WATERBURY FILING NO. 1 EL PASO COUNTY, CO CONSTRUCTION SET FEBRUARY 2023

EPC STORMWATER REVIEW COMMENTS IN ORANGE BOXES WITH BLACK TEXT

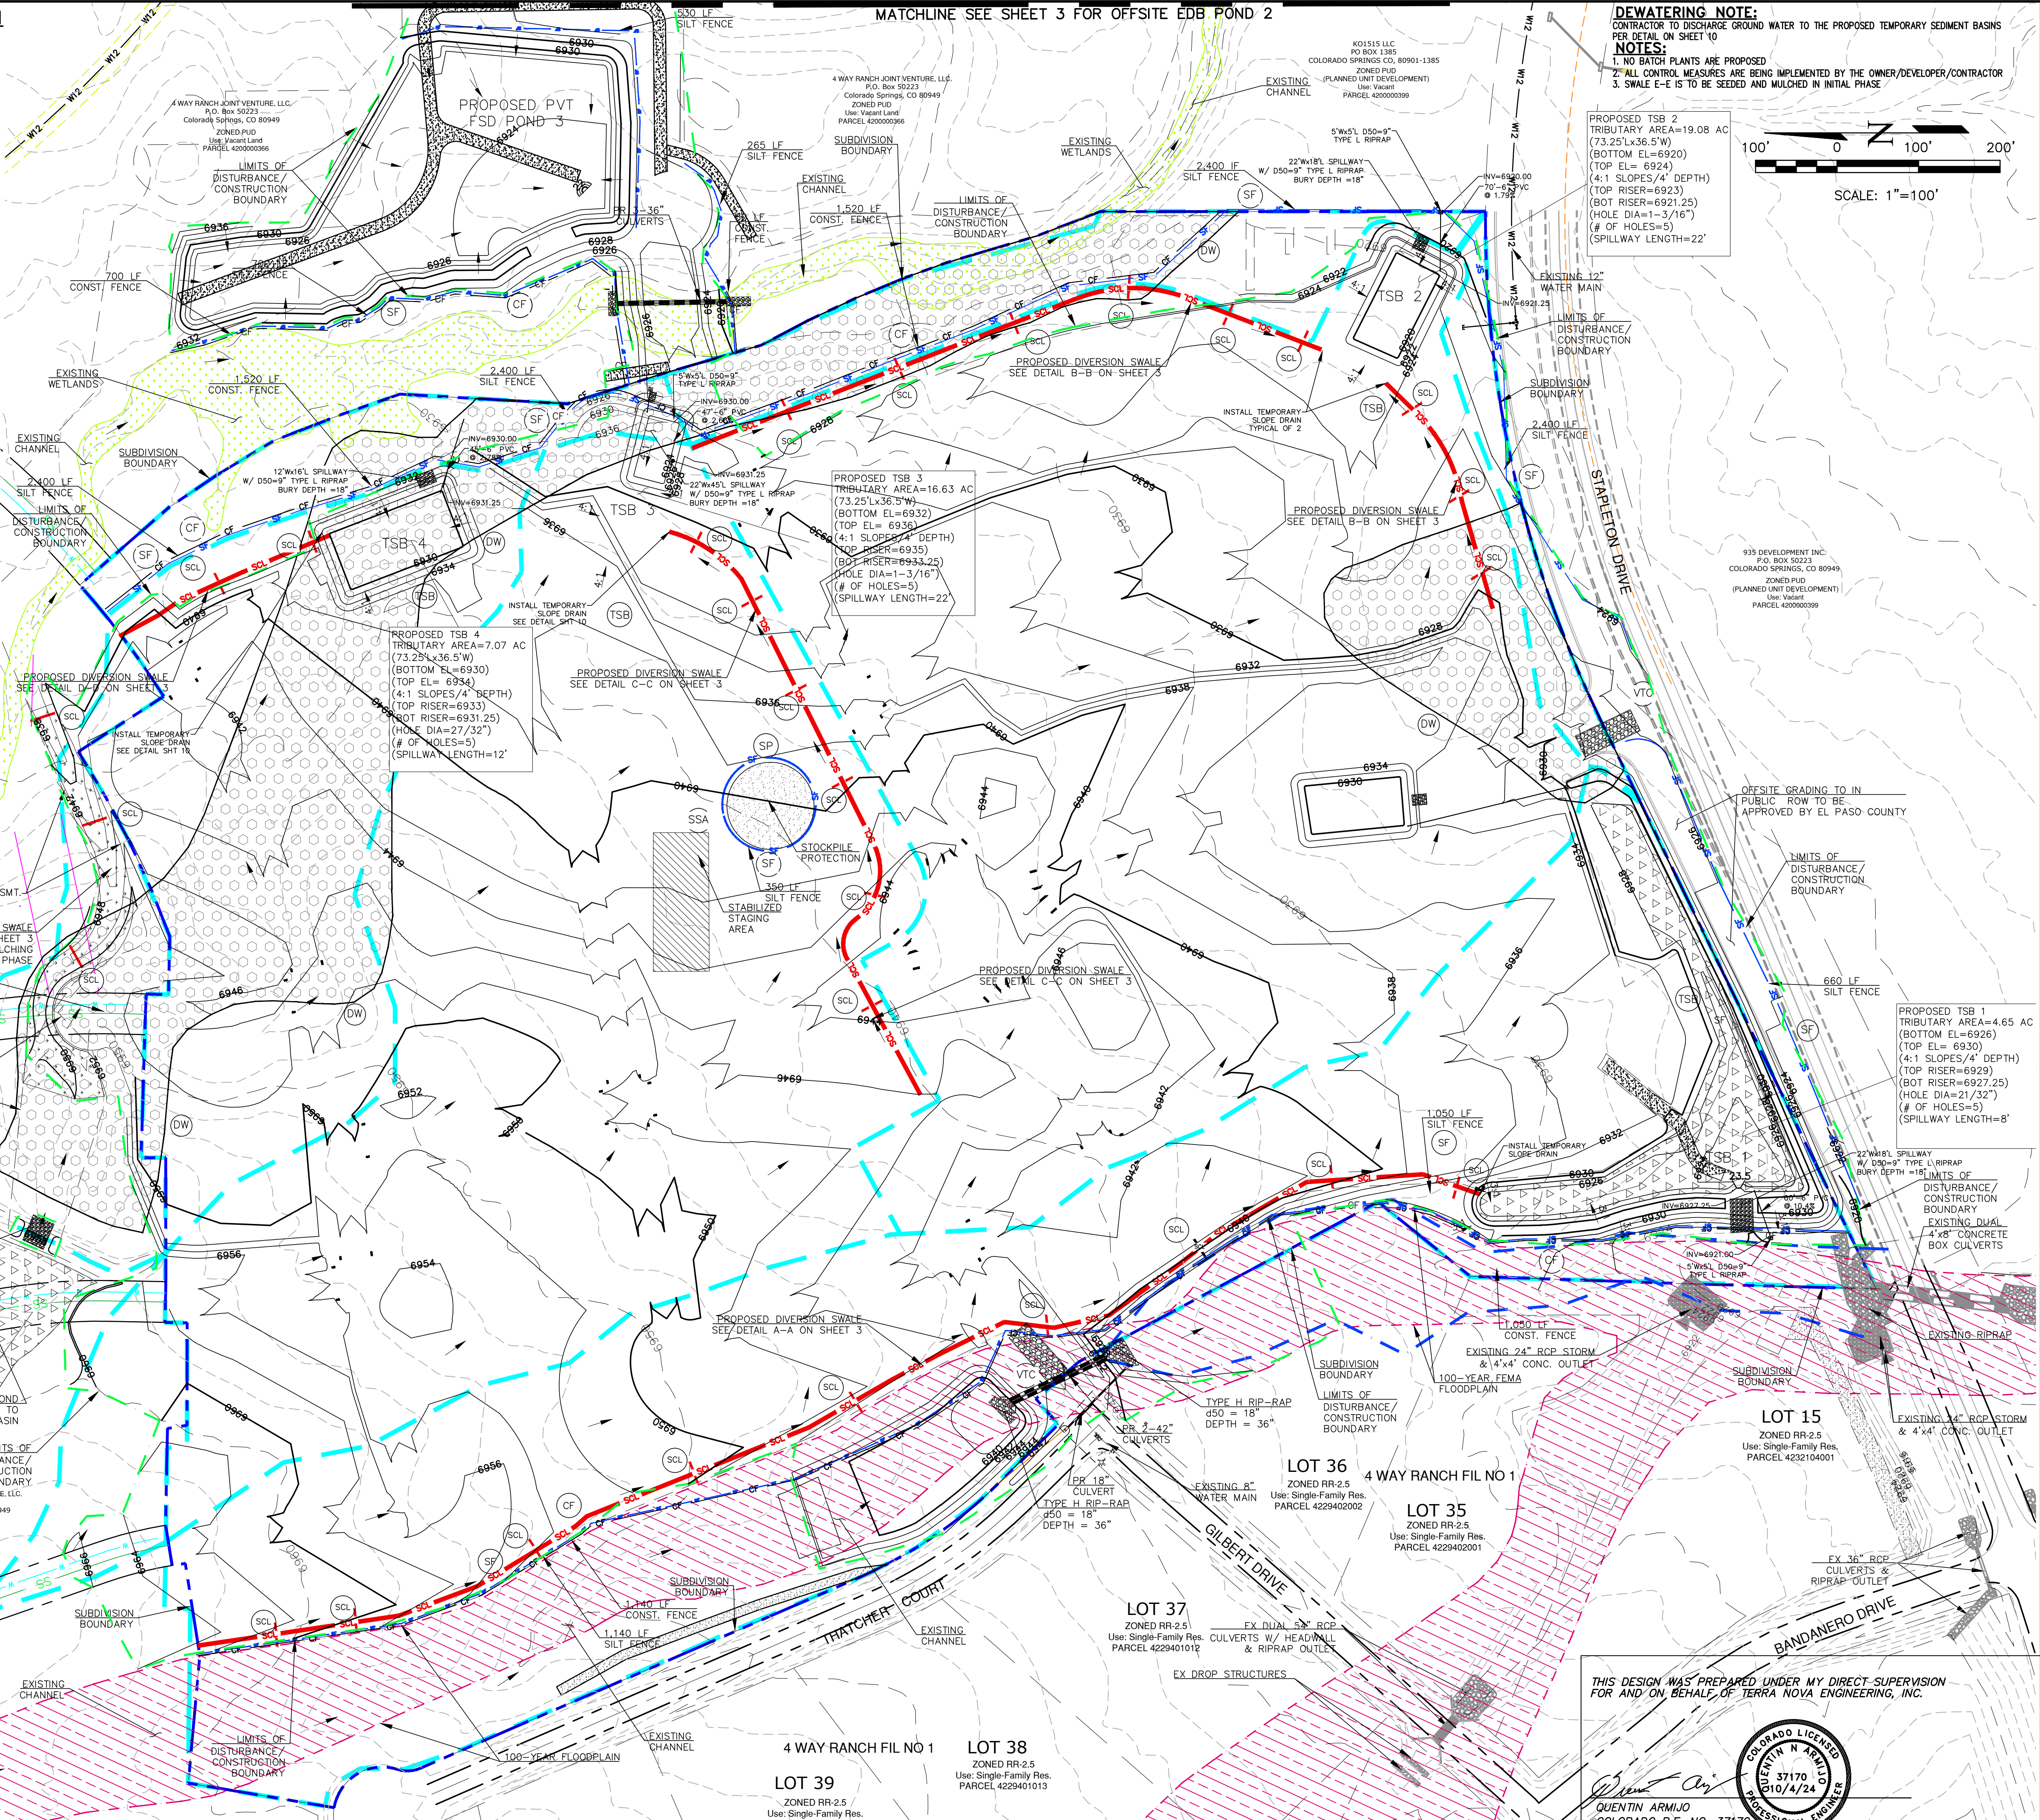
Add a general note: all areas to be vegetated with permanent seeding should also be temporary stabilized via track rolling or some other means.

GEC Checklist Item V. Label all proposed temporary construction BMPs by phase of implementation (initial, interim, final). Show three sheets if needed to designate initial, interim, and final like the PUDSP215 had.

Since the project is changing to Filing 1 and combining all work into one filing, remove mentions to Filing 2 throughout.

Are these the same lines? The pink in the legend appears to be blue.

Put DW in legend and provide detail for if needed.

make sure that all UJA's are shown with the yellow hatching per the legend.

Label existing culvert and riprap.
